**A14**  
**Cambridge to Huntingdon**  
**improvement scheme**  
Development Consent Order Application

**Highways England's comments on the Written Representations**  
**Report 3: Environmental Statutory Organisations**

Development Consent Order Application  
Response to written representations  
(Report 3: Environmental statutory bodies)

**07 July 2015**

**FLOOD COMPENSATION AREA
(FCA 20) SECTION 20A - 20A
WORKS PLANS SHEET NO. 16**

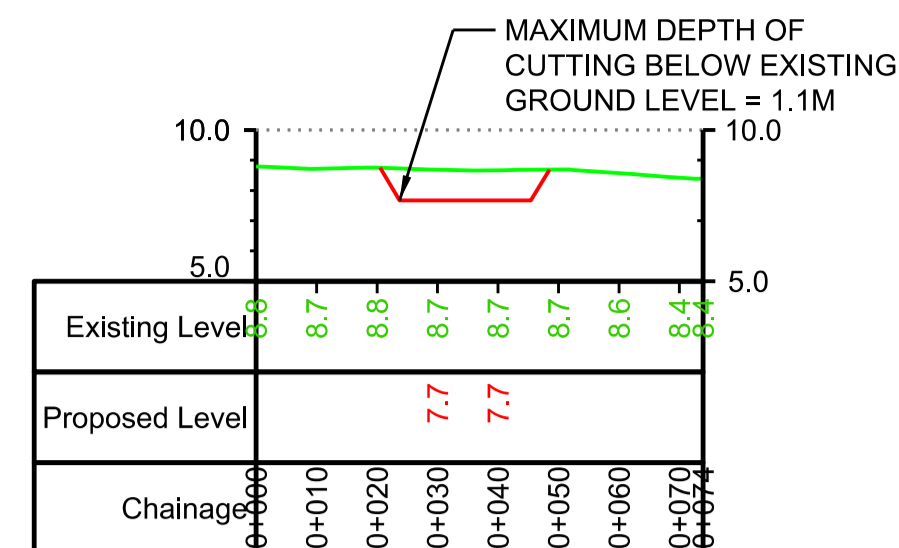
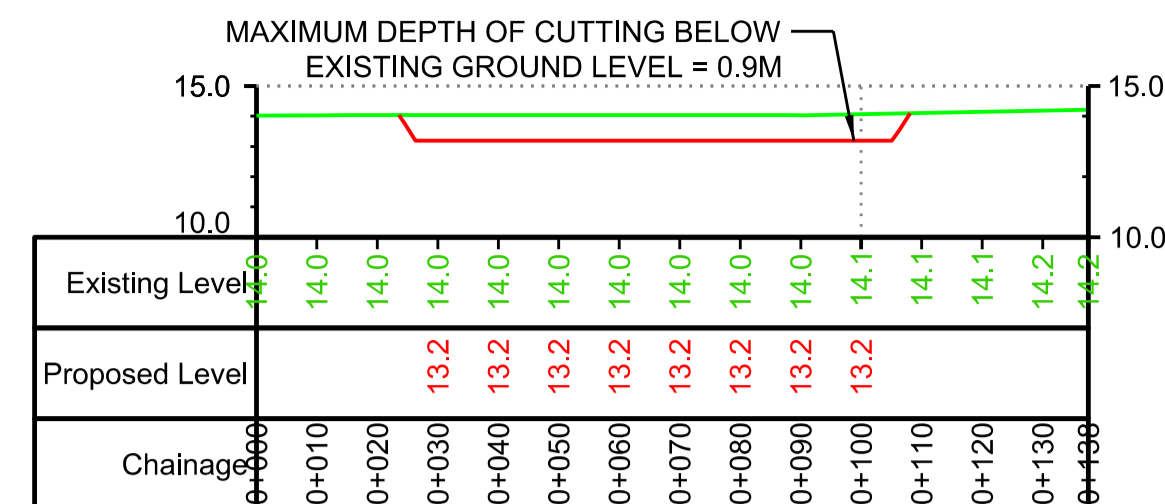
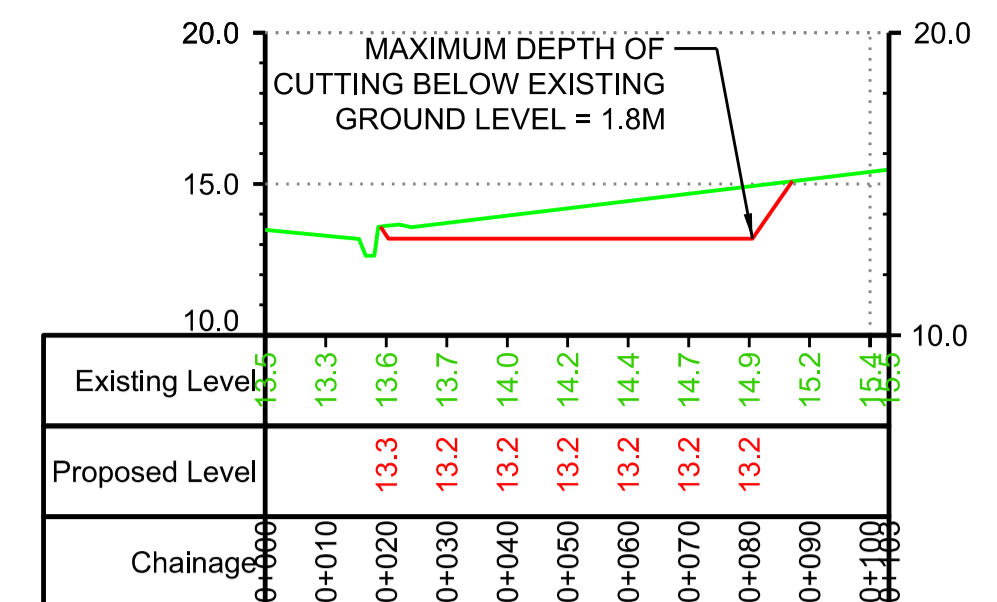
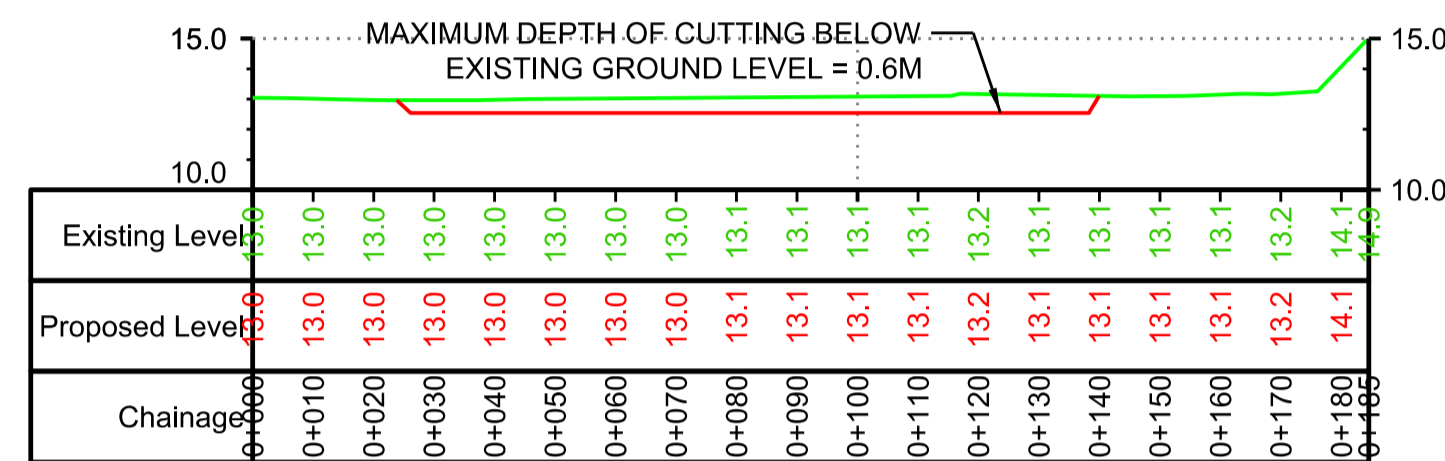
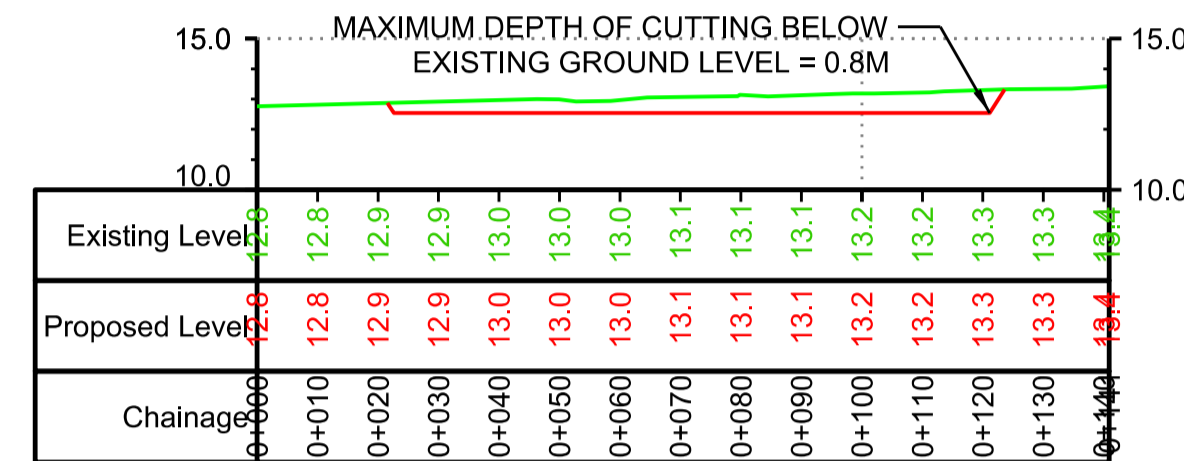
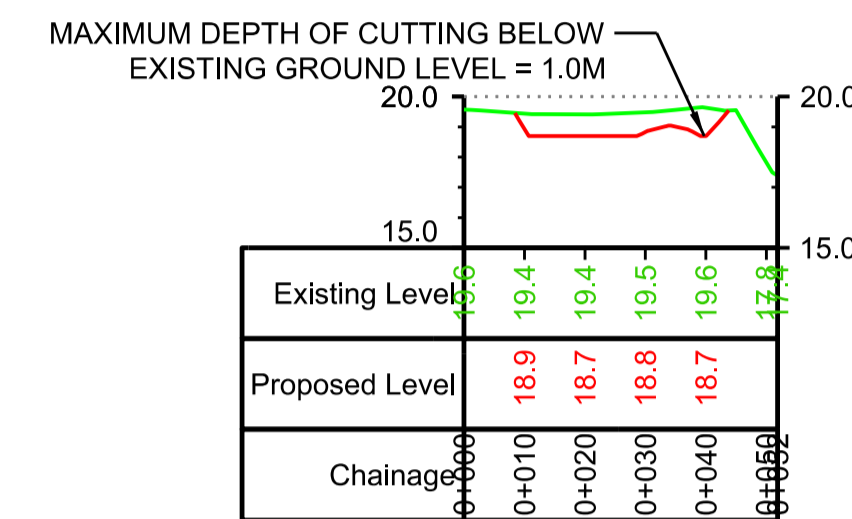
***“Several of the proposed flood compensation areas are shown to be within Flood Zone 3, which is unacceptable as they will not provide the required level for level floodplain compensation and could increase flood risk elsewhere. These areas will need to be relocated unless evidence can be provided to demonstrate that these areas are not currently in the floodplain.***

***“Some of the FpC areas are not aligned with the existing floodplain and therefore may not operate effectively.***

***Some of the FpC areas are not in direct contact with the existing floodplain and therefore will not act in the same way as the existing floodplain that is being lost to the scheme. This could result in an increase in flood risk to third parties.”***

2.5.15 Further hydraulic modelling is currently being progressed by Highways England to refine the design of the floodplain compensation areas in question. The results will be presented to the Environment Agency during the examination to demonstrate that the floodplain compensation areas provide the necessary flood risk mitigation.

2.5.27 Where floodplain compensation areas are located within the current Flood Zone (please refer to our response to Section 1.17) it is as a result of a discrepancy between the flood extent predicted by the hydraulic model used to assess the impact of the scheme and that used by the Environment Agency to define the flood zone. Highways England will submit its hydraulic models to the Environment Agency for review to agree the revised flood zone extent.
